DECISION DELEGATED TO DEVELOPMENT MANAGER

Application No: H08-0724-21 **Applicant:** MedicX Properties V Ltd.

Proposal: Details of surface water drainage & foul and surface water disposal (Conditions 3 & 4 of H08-0475-21)

Location: Gosberton Medical Centre Low Gate Gosberton

Drawing number:
482-151

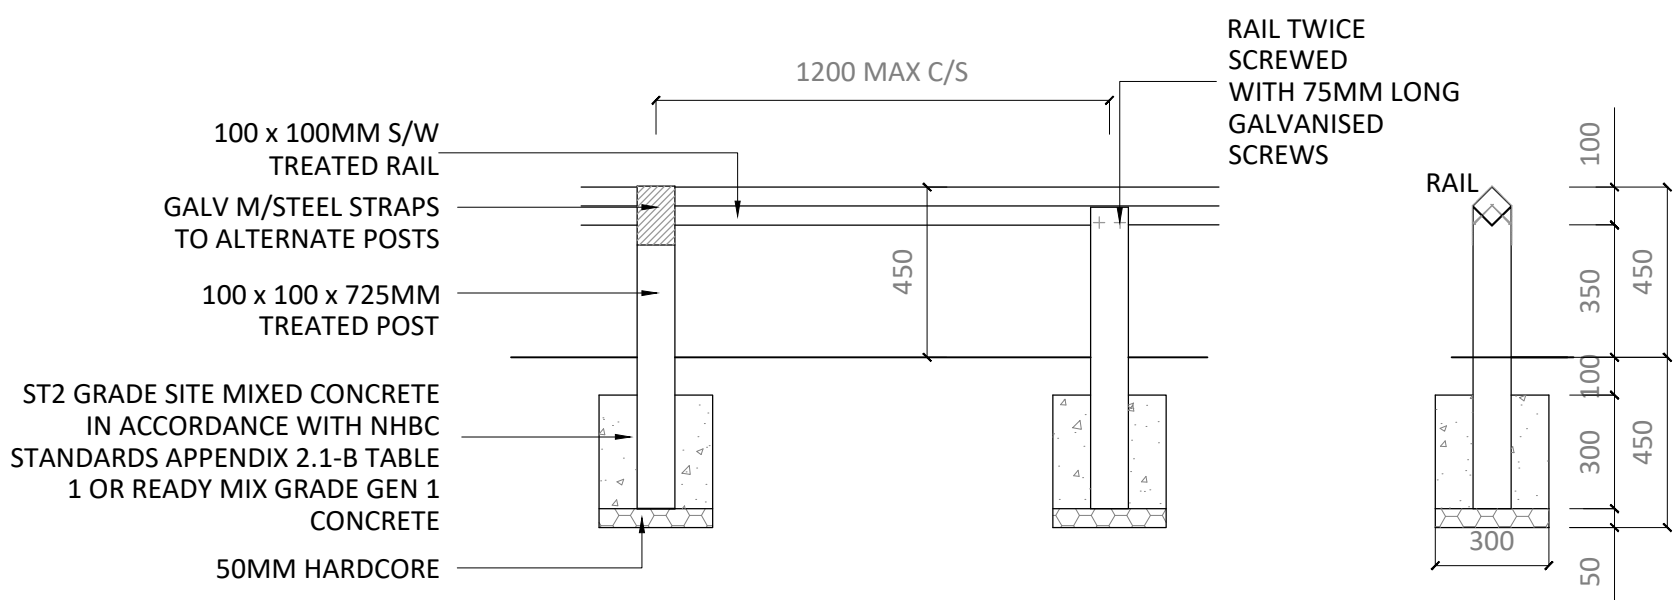
Surface water would be directed inwards and away from the site boundaries as shown on plans 482-151 Rev B and GMCG-BSP-ZZ-XX-DR-C-0230 Rev P02.

Water would be drained into the landscaping via a gravel margin at the edge of the car park as shown on plans 482-151 Rev B and GMCG-BSP-ZZ-XX-DR-C-0230 Rev P02. As such condition 4 can be discharged.
